DECISION DELEGATED TO HEAD OF PLANNING

Application No: H16-0154-24 **Applicant:** Mrs Leyland

Proposal: Proposed two storey side extension with garage conversion and proposed car port

Location: 9 The Chantry Spalding

DRAWING NUMBER:	AJA / 1294 / 23 / 01
DRAWN BY:	HA

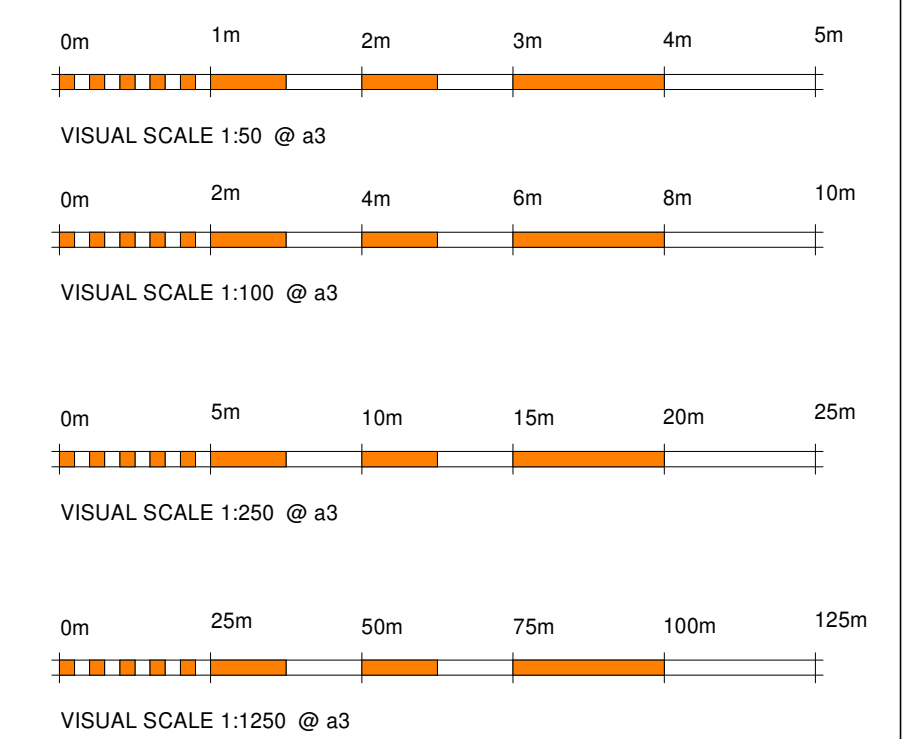
The proposed extension would appear as a continuation of the host dwelling. The use of matching scales and materials ensure that visual continuity is maintained. As such, the impact upon the character of the area is limited.

The proposal would not create significant levels of overlooking. The windows located in the rear and side elevations would face onto the drain and a significant distance from any dwellings as to prevent overlooking. The ground floor windows would be obscured via the existing boundary treatments, preventing overlooking. The first-floor window in the principal elevation would also not increase overlooking. Due to the angle the window would be positioned at, any views into the neighbouring 7 The Chantry would be at oblique angles.

AJA/1294/23/02a

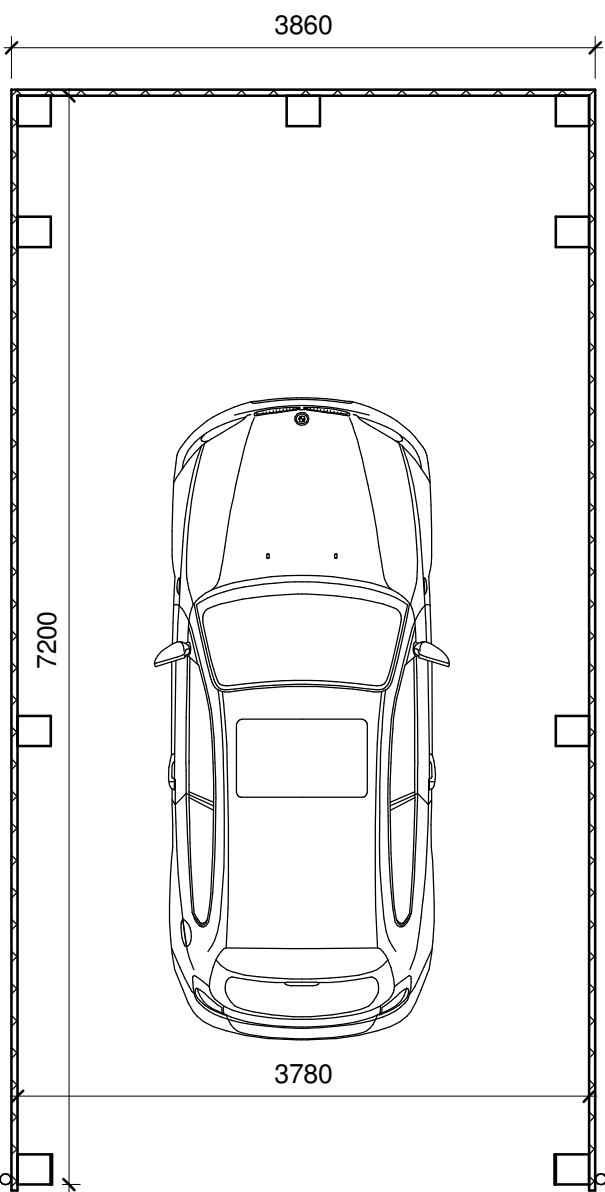
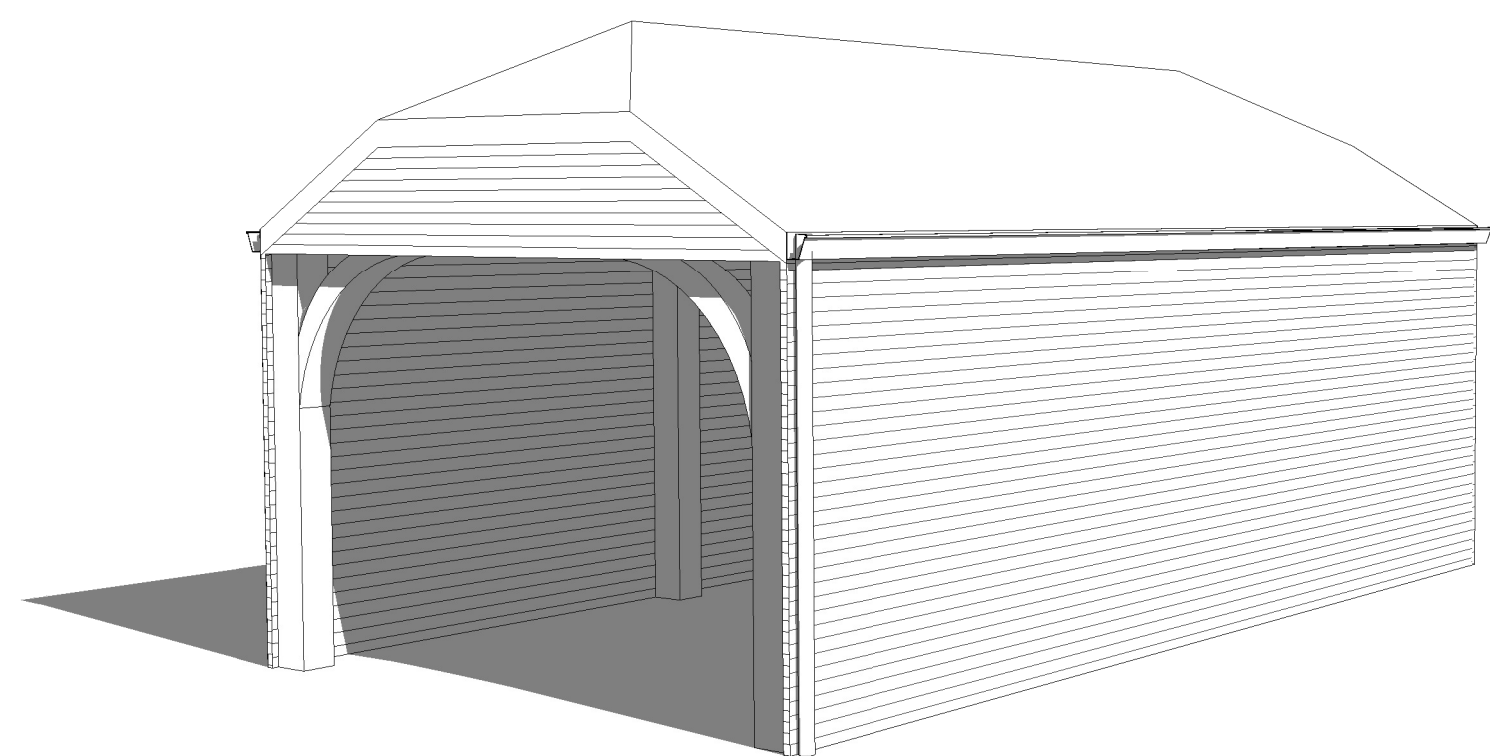
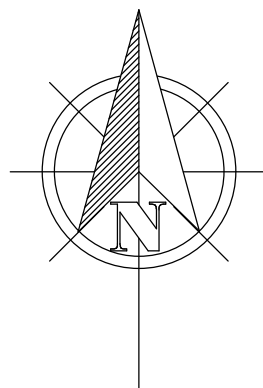
The amended scheme has significantly reduced the scale of the proposed carport, bringing the proportions more in line with the existing shed. As the proposed carport would be well set back from the road, and largely obscured from the street scene, the impact upon the character of the area would be limited. While timber carports are not common in the immediate area, they are a fairly typical development, and as such would not appear out of character.

The proposed car port would only be marginally taller than the existing outbuilding. As a result, it is not considered that the proposal would have a significant overshadowing effect. Furthermore, it is of note that any potential overshadowing would fall onto a small strip of side garden, which itself is currently largely in shadow due to the host dwelling.
